Able Marine Energy Park

Material Change 2

Applicant's Response to

the MMO's D3

Figure 6.5: Early stage reclamation - Predicted peak increase in depth-averaged suspended sediment concentration above background over a spring-neap cycle

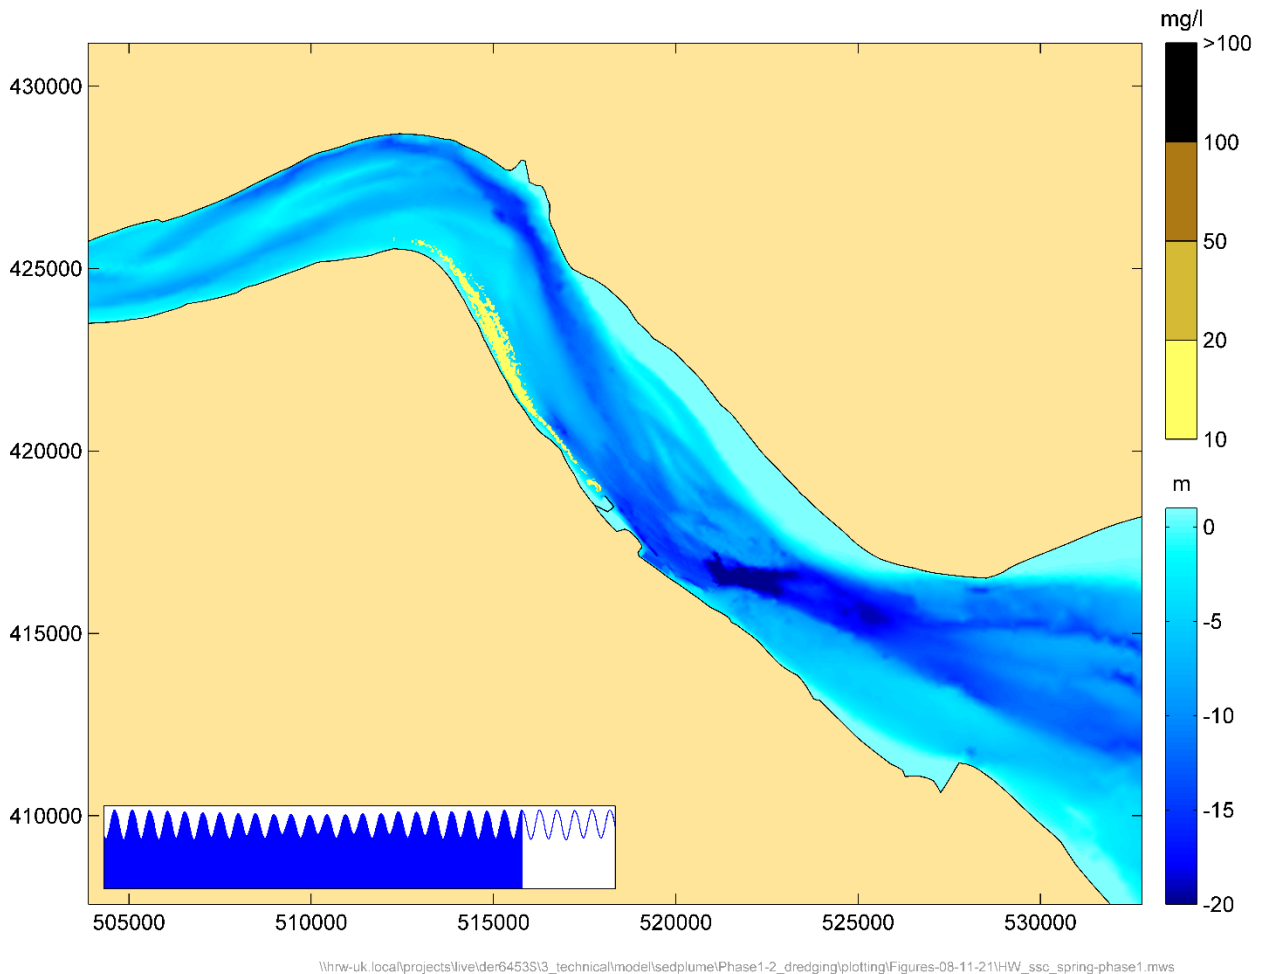
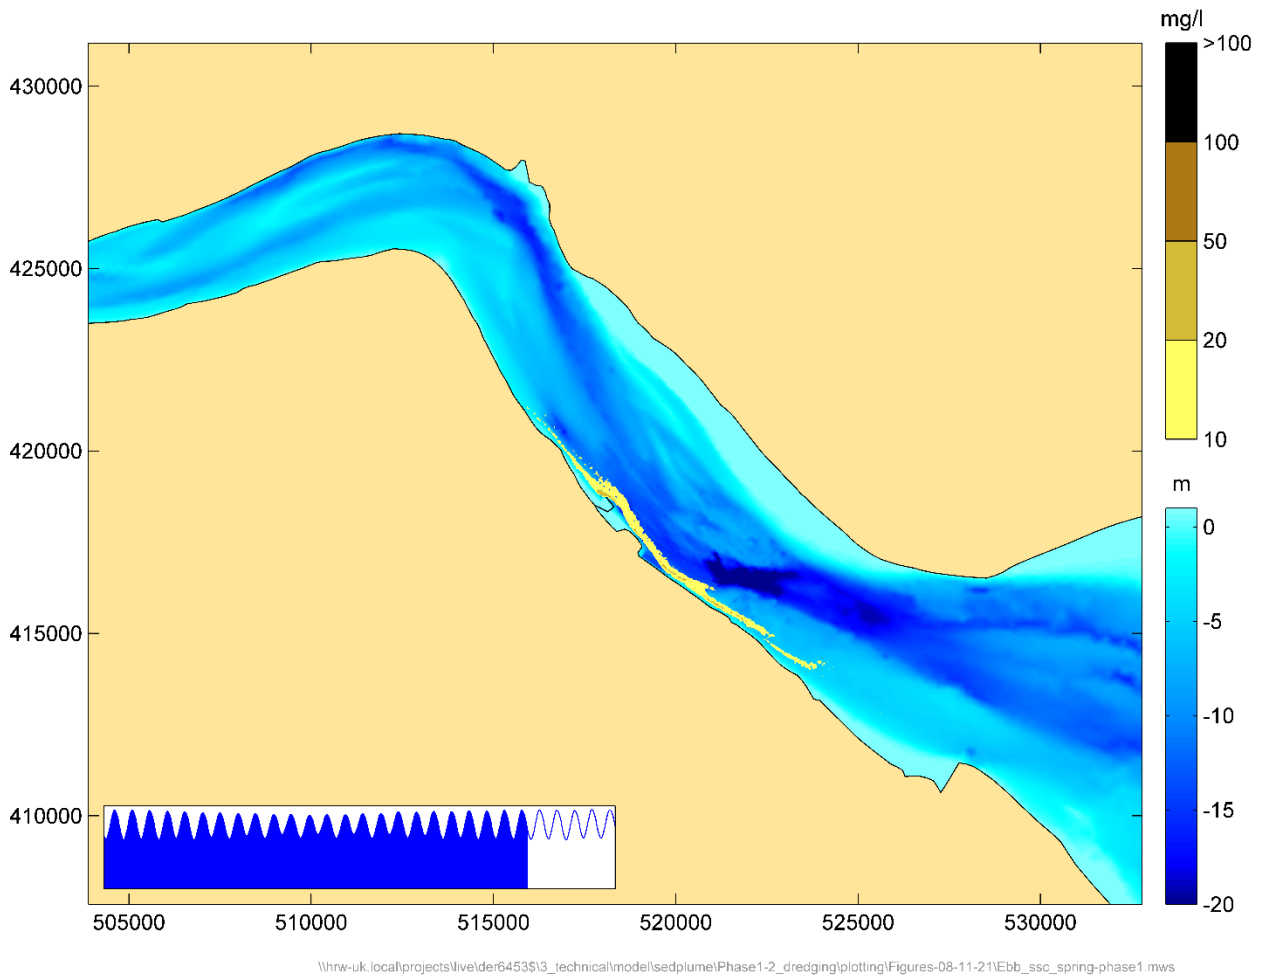
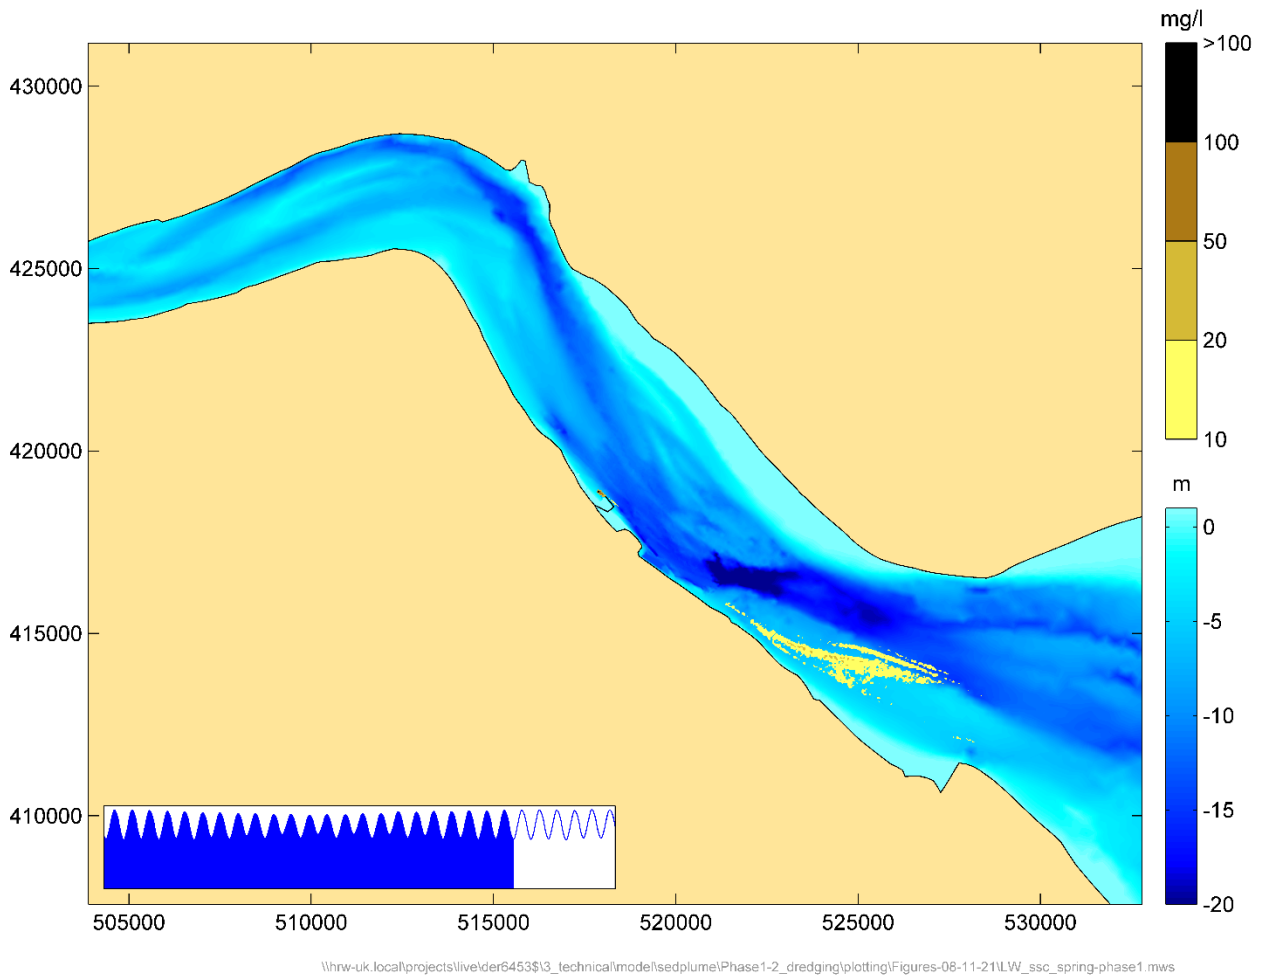
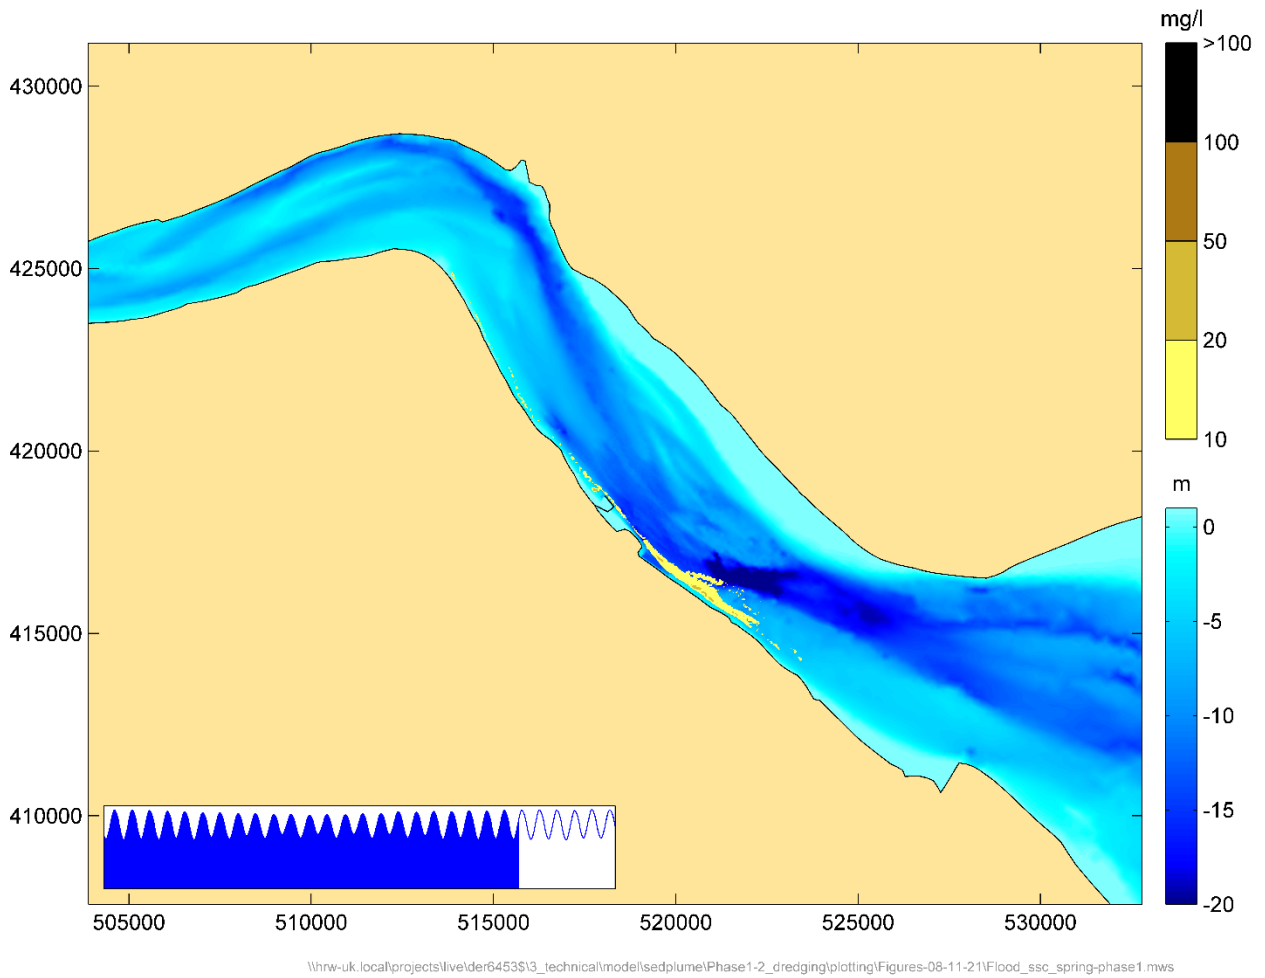
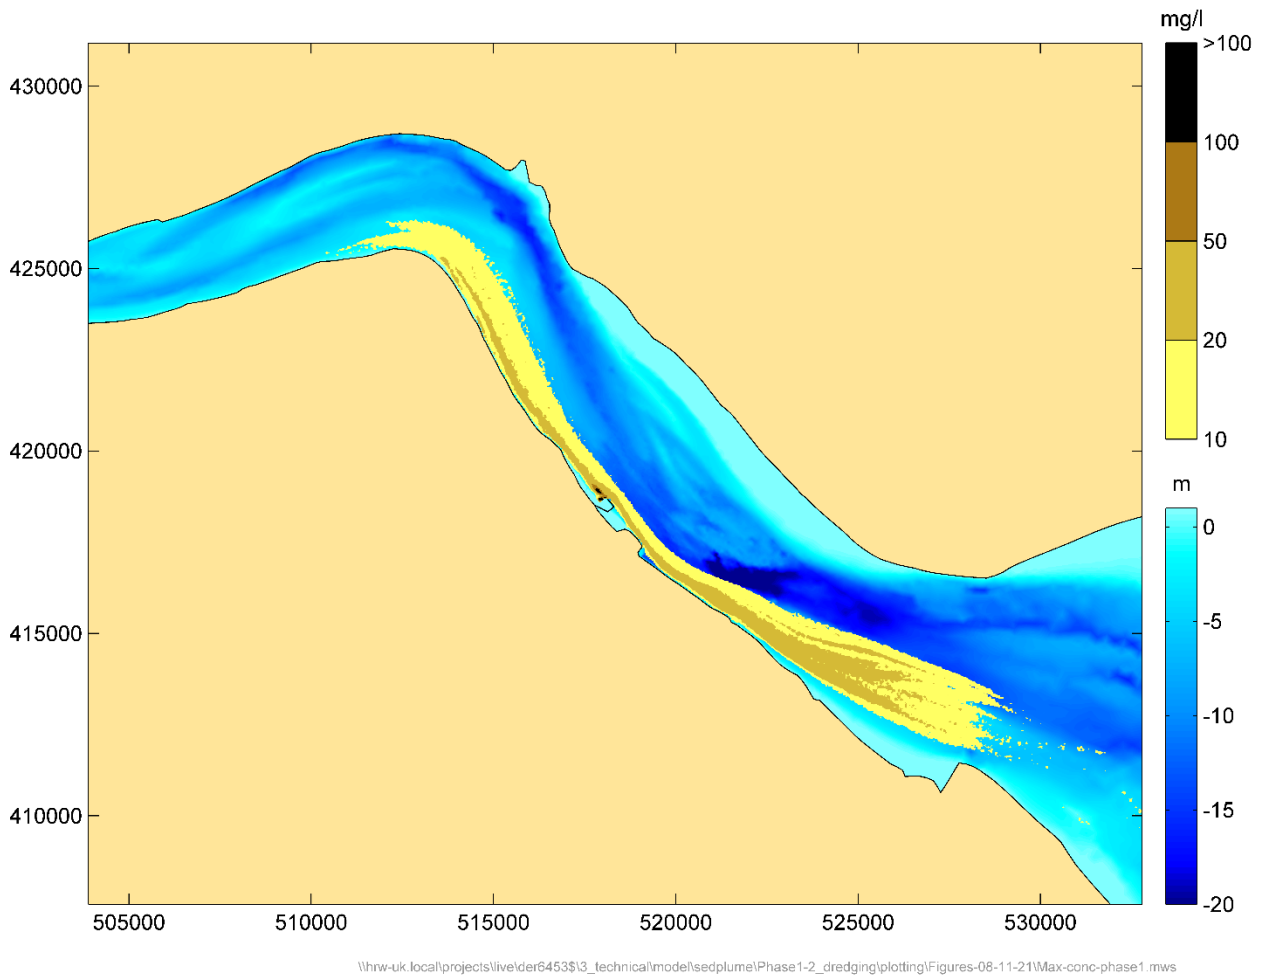
3.1 The MMO note that Sections 6.2.1 (early phase) and 6.3.1 (late phase) present data on depth-averaged suspended sediment concentration (SSC) increases, which indicate (absolute) increases over background of up to 50mg/l. The general conclusion is that the absolute increases are low in an estuary context. However, Section 4 (background SSC) lists peak SSC (at various estuary locations around the site) which the MMO consider would be more valuable presented as background values (while minimum values would be indicative of the potential worst case instantaneous change). It can be assumed that the works will occur at 'off-peak' times (i.e., dredging is not likely to occur in excessive weather/flow states associated with peak SSC) so the relative increase over background is not well represented. While the MMO appreciate that the peak value shows that very high SSC is not unusual in the location, comparison with the mean would make a stronger point with respect to the significance of the chronic effect.

The approach adopted in the HR Wallingford sediment plume report to the presentation of predicted increases in sediment concentrations arising from dredging activities is the same as in previous reports. Results are presented in the form of instantaneous plots of suspended sediment concentration levels above background levels at specific stages of the tide and as a plot of the envelope of peak suspended sediment concentration predicted over the course of the simulation period (a spring-neap cycle) regardless of the state of the tide.

Available information on measured concentrations in the vicinity of the AMEP site were described in HR Wallingford Report DER6453-RT002-R04-00, June 2021 and then summarised in this and previous reports to provide a context for comparison. The general conclusion for the dredging activities simulated is that the absolute increases are comparable to those previously assessed for the amended scheme with BHD loading barges and that the impacts are considered low in an estuary context. This is the important point arising from these further studies.

The MMO are suggesting that the peak SSC described may occur at times of excessive weather or river flow states and that dredging may not occur at these times. This is not necessarily the case for an estuarine environment. The factors most influencing SSC in the vicinity of the AMEP site will likely be tidal range, tidal surge; river discharge/rainfall and local wind wave action. It is not certain that any of these conditions, except perhaps exceedingly high winds, would affect the dredging activity (and as acknowledged, dredging vessels would be very unlikely to operate in such conditions in any case). The figure below (Figure 12 from UES Appendix UES9.3) shows the time measurements of suspended sediment concentration at two locations in proximity to the AMEP site measured over a year. The strong correlation with the spring-neap tidal cycle can clearly be seen, with elevated concentrations (typically peaking at 2,000 to 3,000 mg/l) at the time of spring tides and reduced concentrations at the time of neap tides (typically peaking at 200 to 500 mg/l).

Given the low levels of suspended sediment increase above background levels predicted to occur for the simulated dredging activity and the time varying nature of natural suspended sediment concentrations over the course of a spring-neap cycle it is not appropriate, in the view of HR Wallingford, to consider the plume concentrations, for this particular dredging activity, against the

mean measured concentrations. This approach was not requested by the MMO for other simulation results presented.

Figure 6.6: Early stage reclamation - Predicted deposition of fine sediment over a spring-neap cycle

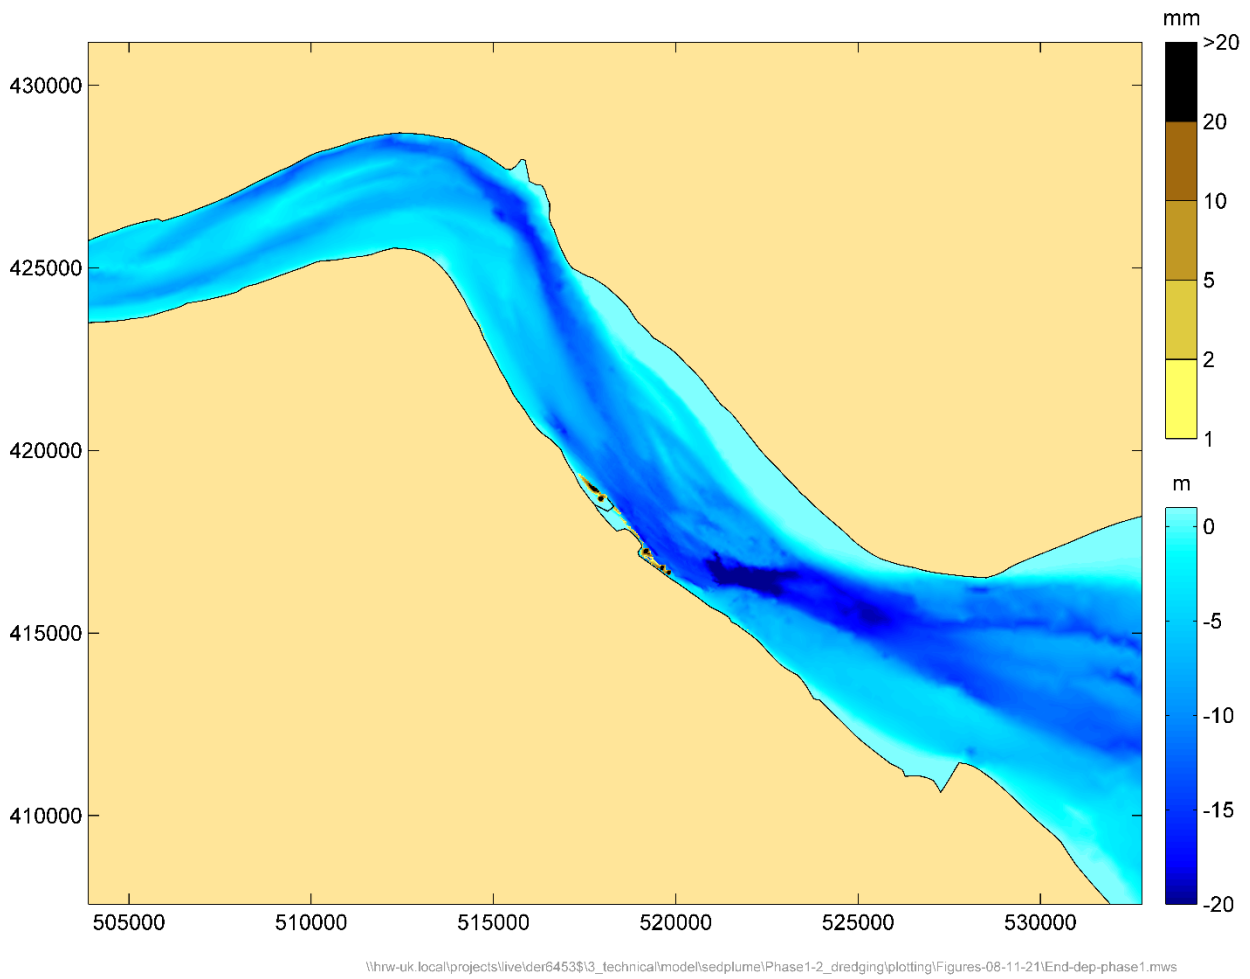
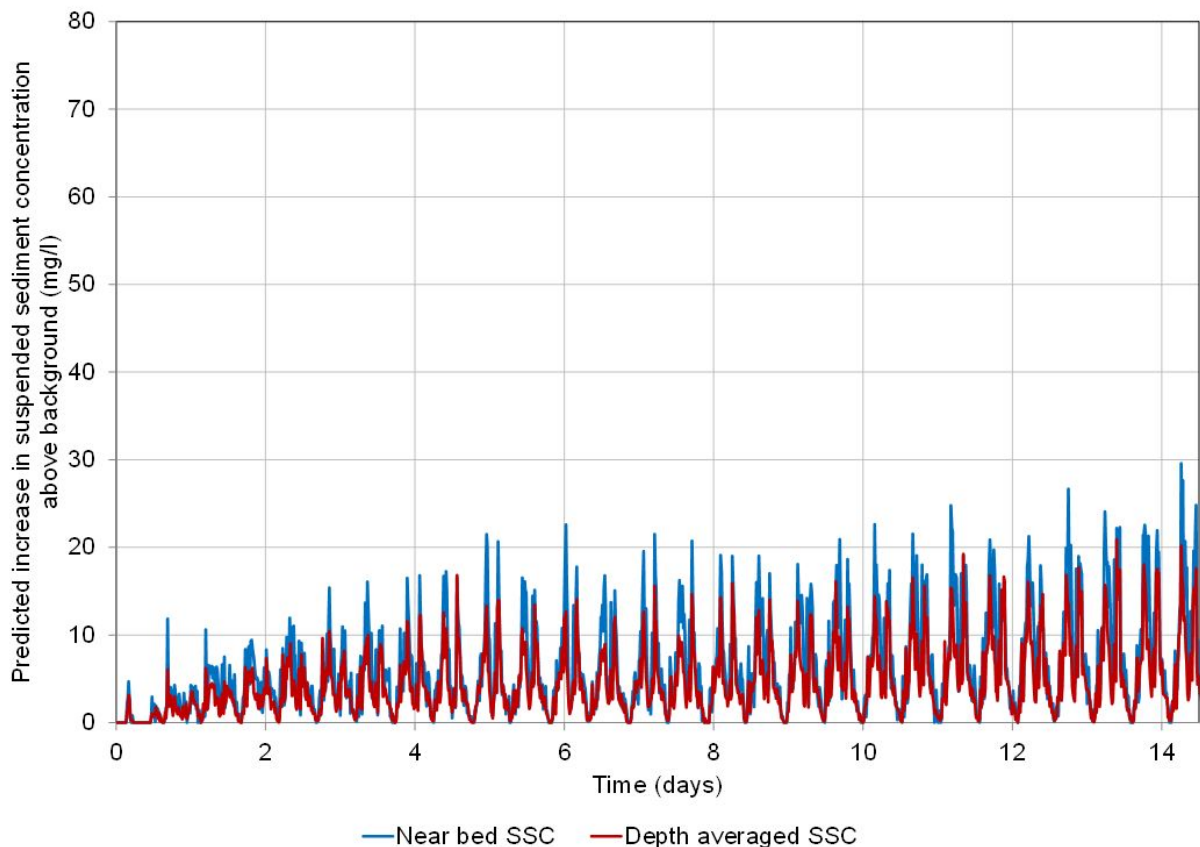
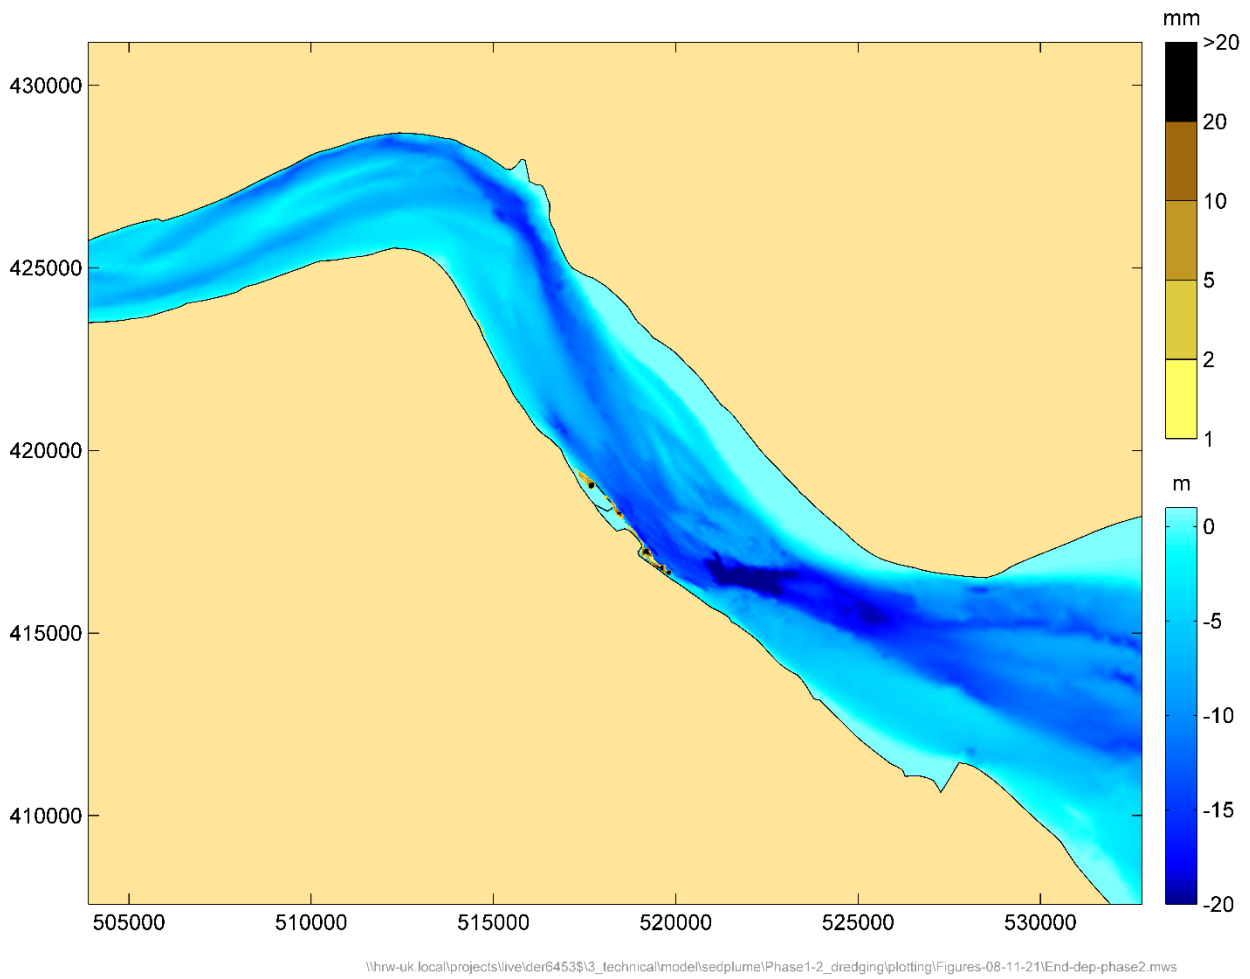
3.2 The MMO also consider that the report does not discuss in significant depth the change in SSC relative to the previous phasing of construction works - the nominal subject of this report being the relative consequence of changing the construction sequence. However, the report also presents (i) deposition in Sections 6.2.2 and 6.3.2 (being little more than a few mm per tidal cycle, and therefore effectively undetectable by depth monitoring methods), and (ii) the increase in infill at nearby berths (Table 6.1 and 6.2). The increase in infill relative to previous modelling is largely negligible, except for the nearby South Killingholme Oil Jetty – here, the infill increases 12-fold (to 38m³ per tidal cycle) for the first phase and 70-fold (to 219m³) in the late-stage results. The MMO consider that it would be of value to know how these volumes compare with typical maintenance dredge requirements i.e., an explicit demonstration that maintenance dredge requirements are unaffected by this volume. In addition, for further confidence, the MMO would like to see a simple numerical (or graphical/mapping) indication of the relative magnitudes of SSC increase relative to the mean, and infill at the oil jetty berth.

The report presents the results in the same format as for previous plume modelling studies and hence presents patterns and rates of deposition and volumes of infill at nearby berths. Importantly the report uses the flow patterns arising from the part constructed works. The previously published results used either the baseline flow conditions, representative of the very start of the construction

The results of the new plume simulations show that compared to the previous simulations the predicted increases in infill at nearby berths are negligible except at South Killingholme Oil Jetty (SKOJ) where additional infill is predicted as a result of the combined effects of the changes to the hydrodynamics associated with the stage of construction, the location of the BHD operation and the effects of reclamation run-off compared to the previous simulations of BHD seawards of the AMEP quay.

The Applicant understands from the Operator that no maintenance dredging is currently carried out at SKOJ so any siltation that occurred would likely be due to AMEP if there were no other wider changes in the estuary or at other berths. For the downstream Immingham Riverside berths including SKOJ the average annual quantity dredged and disposed over the period 2016 to 2019 was 3,447,000 wet tonnes. Based on the proposed construction sequence (10 months of reclamation and up to 2 months of BHD operations) the additional monthly infill predicted at SKOJ is between a maximum of 70 m³ and 430 m³. The SKOJ berth will be regularly surveyed during the construction period and protective provisions are in place should there be sedimentation in the berths above the typical background rates.
